23 November 2010

**Major Project 10_0107 – Residential Development – Buildings 1, 2 & 3
61 Mobbs Lane - Epping - Channel 7 Site (Epping Park)**

07 SECTION A

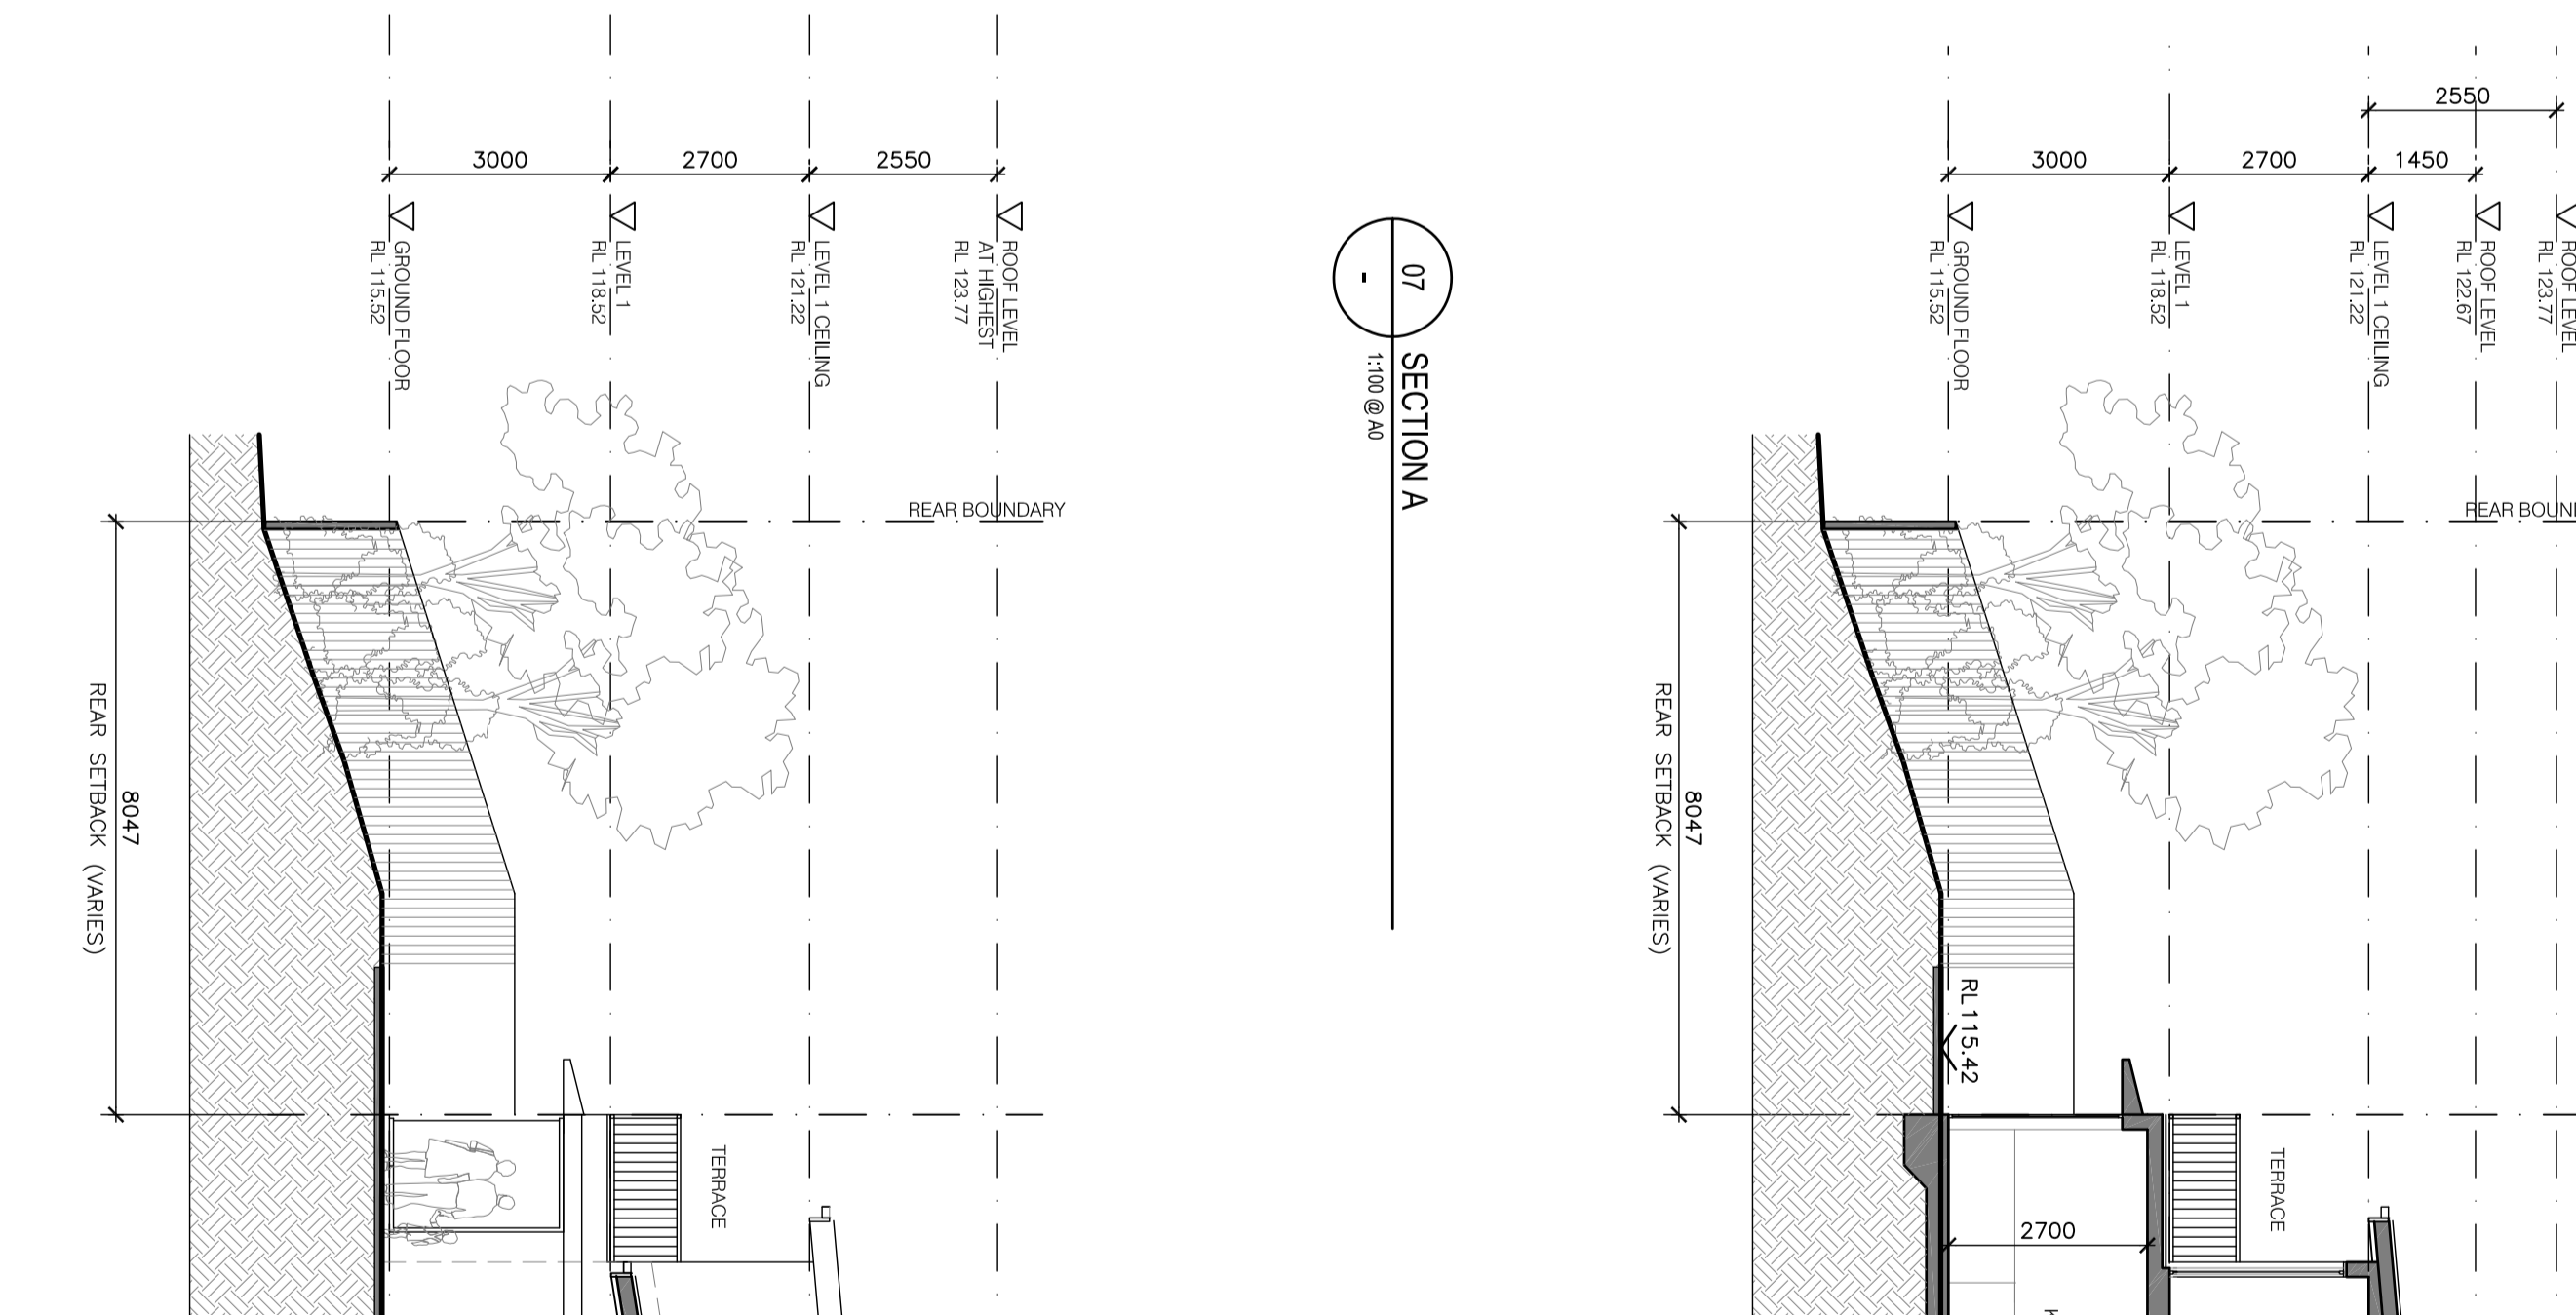
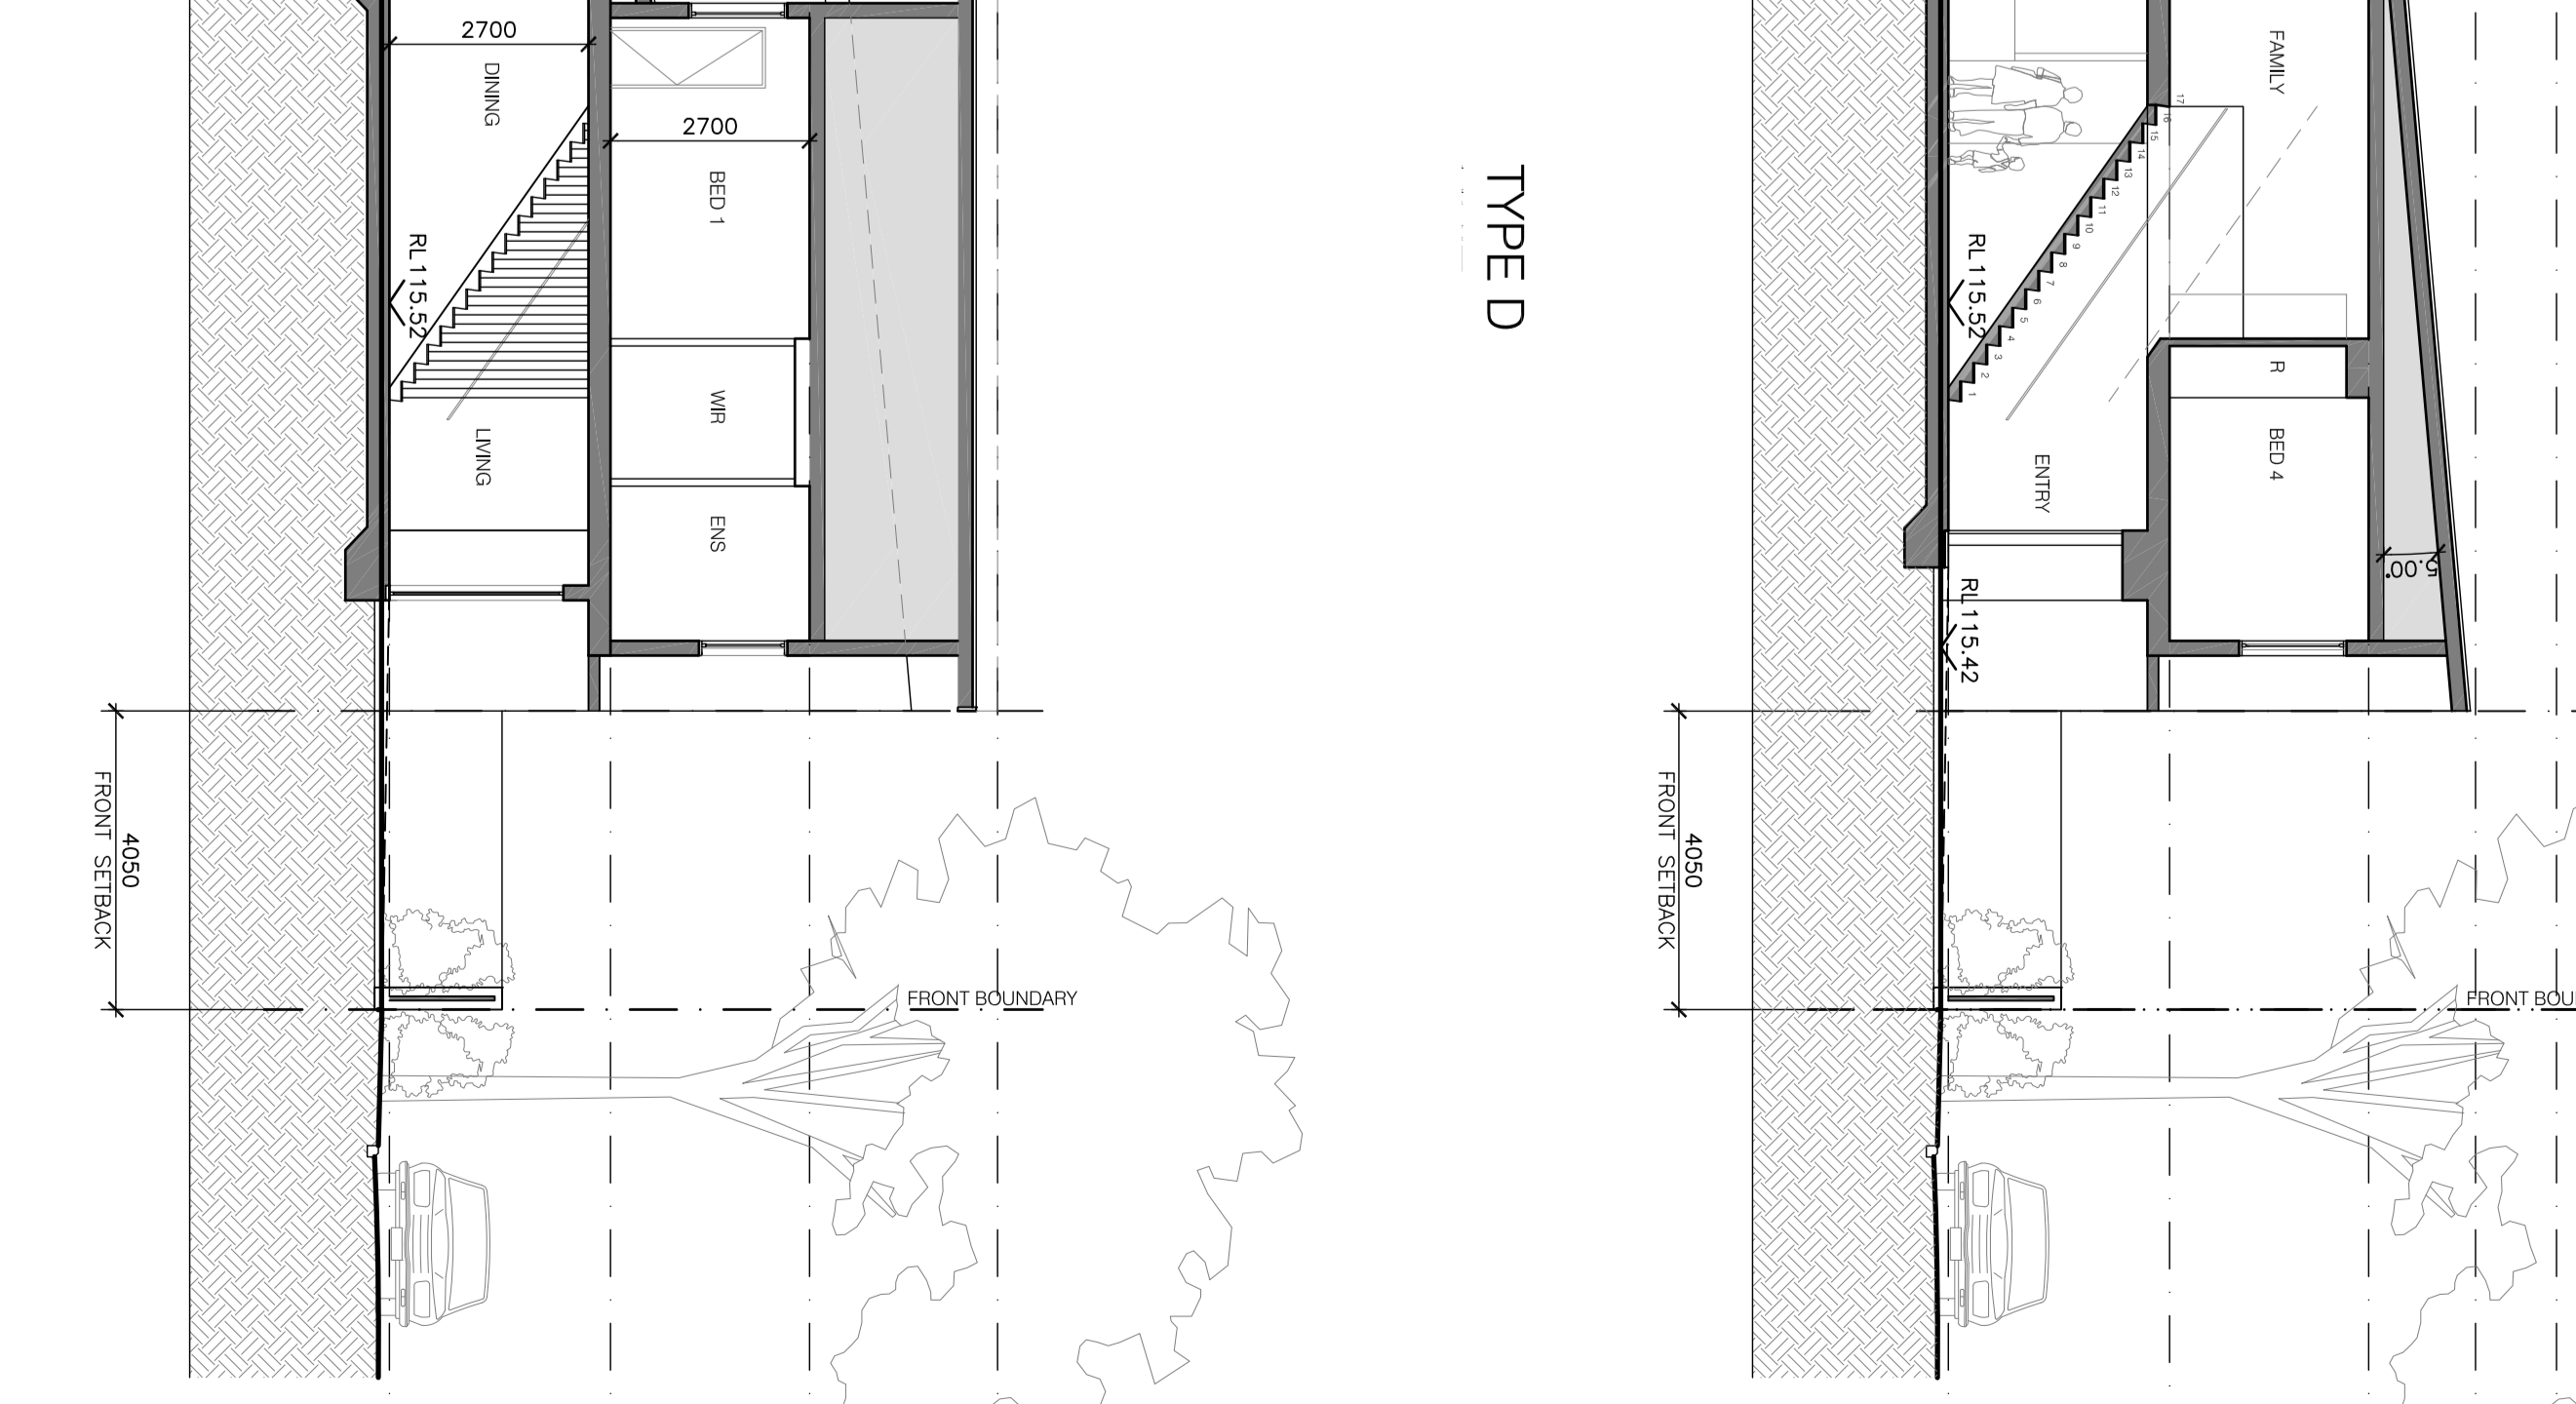
The reproduced Concept Plan is of poor quality and it is unclear if a 6.7m or 8.7m is required to the eastern property boundary adjoining the rear yards of the detached dwellings. The proposal provides a varying rear setback to building 3 of approximately 8m. Clarification is sought about the setback required under the approved Concept Plan to the eastern boundary. If the setback is 8.7m, the proposal should be amended to comply with this requirement to protect the amenity of the adjoining properties, provide greater private open space and landscaping.

The height controls for building 3 within the approved Concept Plan indicates a transition from 2 storeys to single storey towards the eastern site boundary. The application proposes a largely 2 storey building form with a limited single storey component. The proposal also includes roof elements that extend up to 2.75m above the upper level ceiling height for architectural articulation of the long linear building form. This appears excessive and unnecessary.
